From: Contact Centre (CRM) <contact@ribblevalley.gov.uk>
Sent: 12 July 2023 16:27
To: Planning
Subject: Planning Application Comments - 3/2023/0457 FS-Case-531169255

Planning Application Reference No.: 3/2023/0457

Address of Development: Overdale York Lane Langho BB6 8DT

Drawing Title
Proposed Floor Plans and Elevations

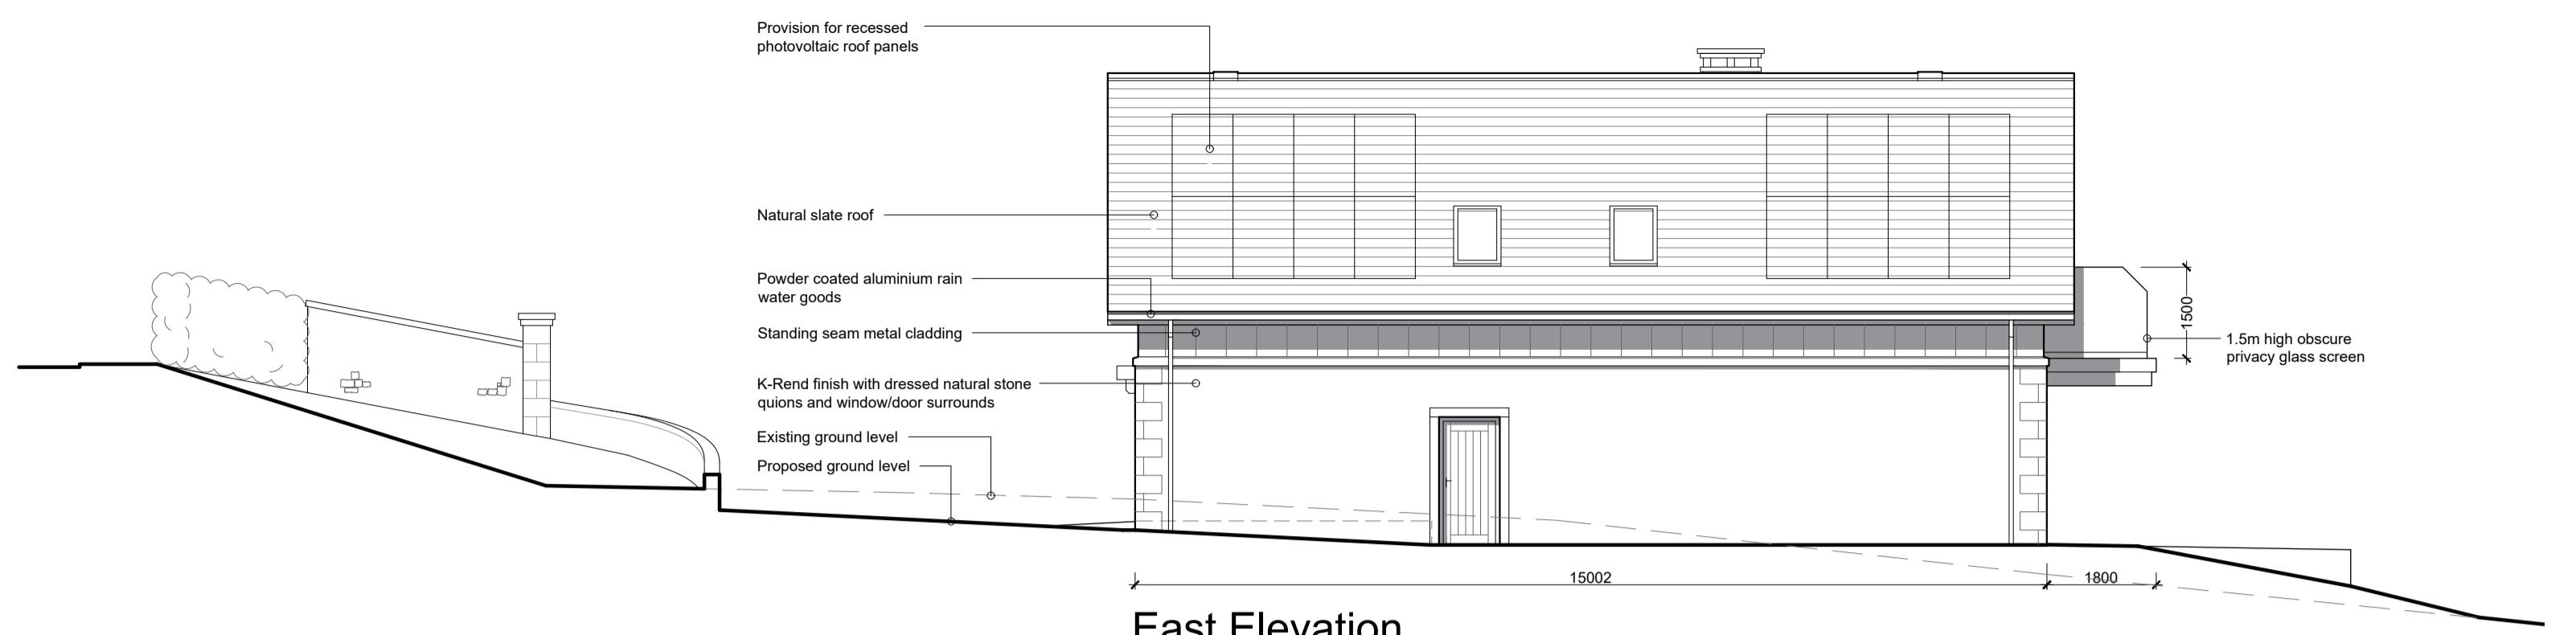
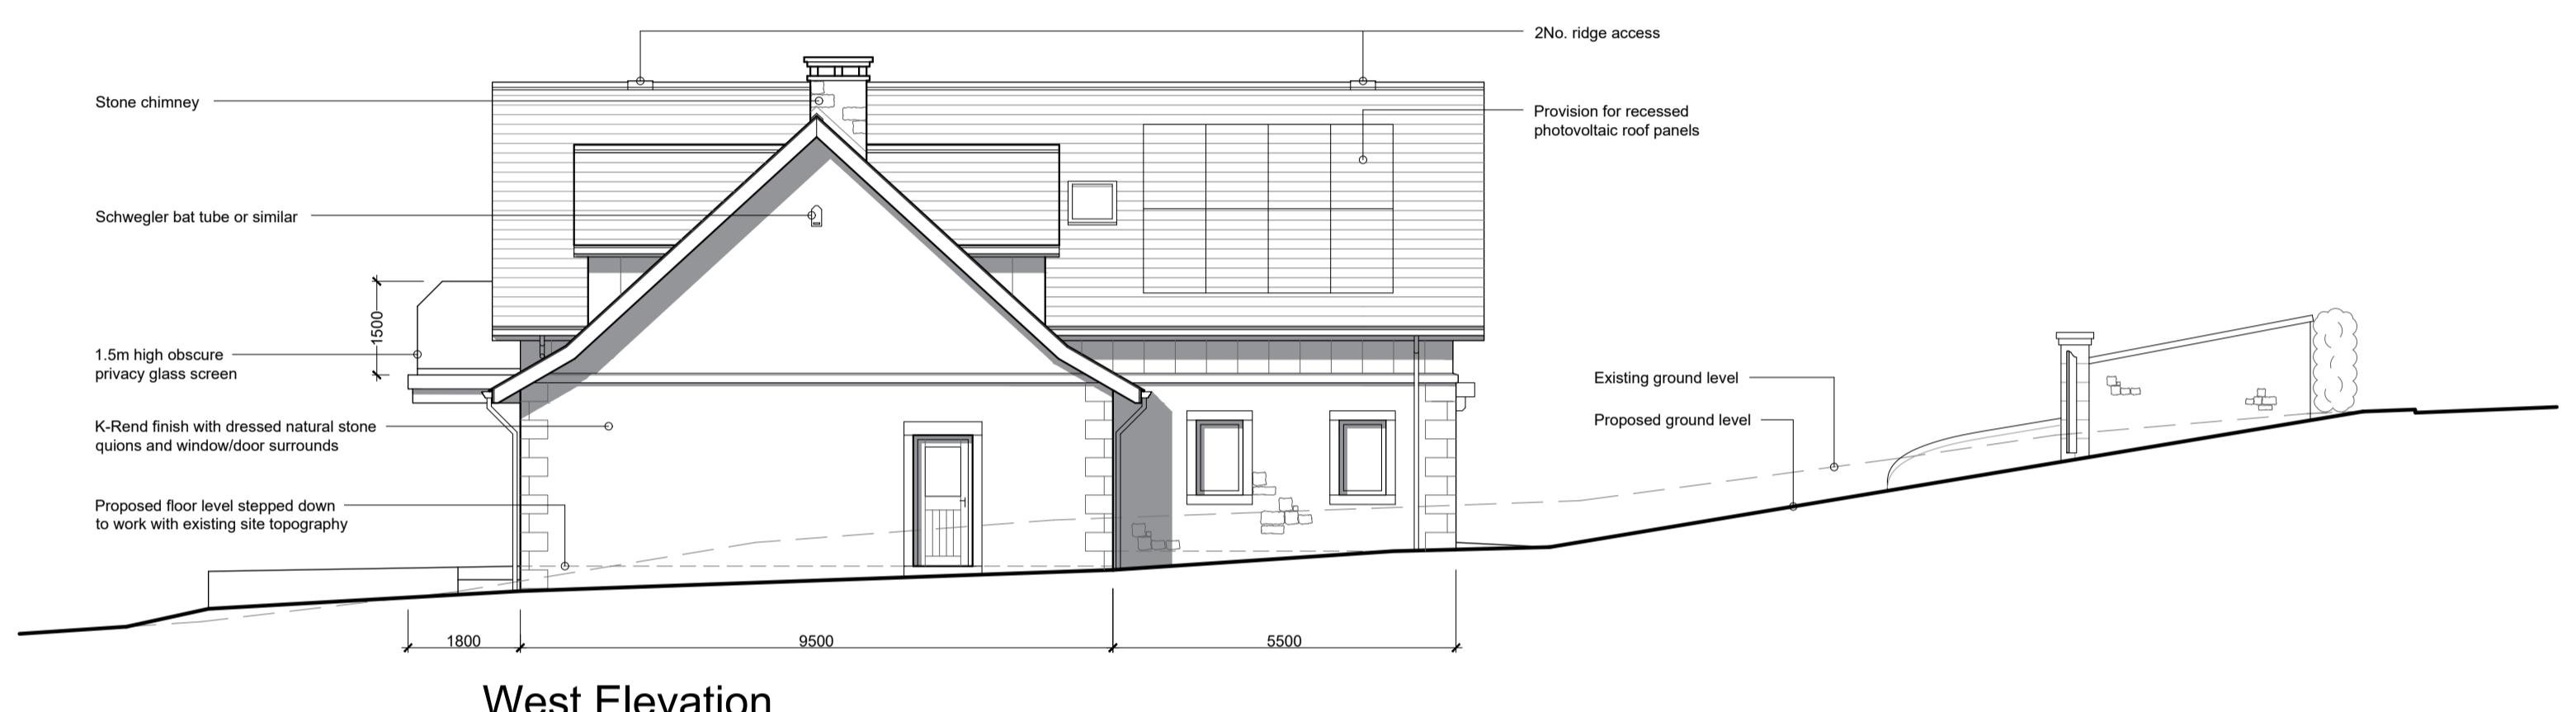
- 1) The revised building width, although minimal, is noted.
- 2) I strongly disagree that this adjustment justifies the SIGNIFICANT INCREASE in height.
(This can be dealt with by digging down further)
- 3) The hedge on the front boundary provided [REDACTED] an effective screen.
I cannot see from the Plans any indication that it was to be removed.
- 4) In any case, why HAS half of it been ripped out BEFORE final approval has bee authorised?
